NSW RURAL FIRE SERVICE

Your reference: SSD 10460
Our reference: DA20200813002921-Original-1

Development Application

EIS - Hume Battery Energy Storage System Project 62 Murray St Lake Hume Village NSW 3691 AUS, 2//DP1165089

Figure 5-1 Access for bushfire protection

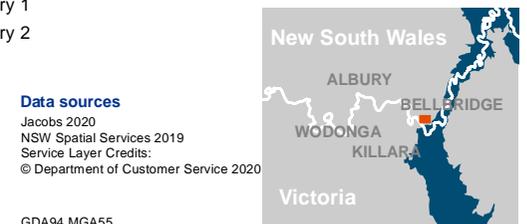
To allow for emergency service personnel to undertake property protection activities, a minimum 10-metre trafficable defensible space, managed as an asset protection zone, must be provided around all critical assets, outside perimeter of the BESS compound and around all areas of unmanaged vegetation being retained within the site.
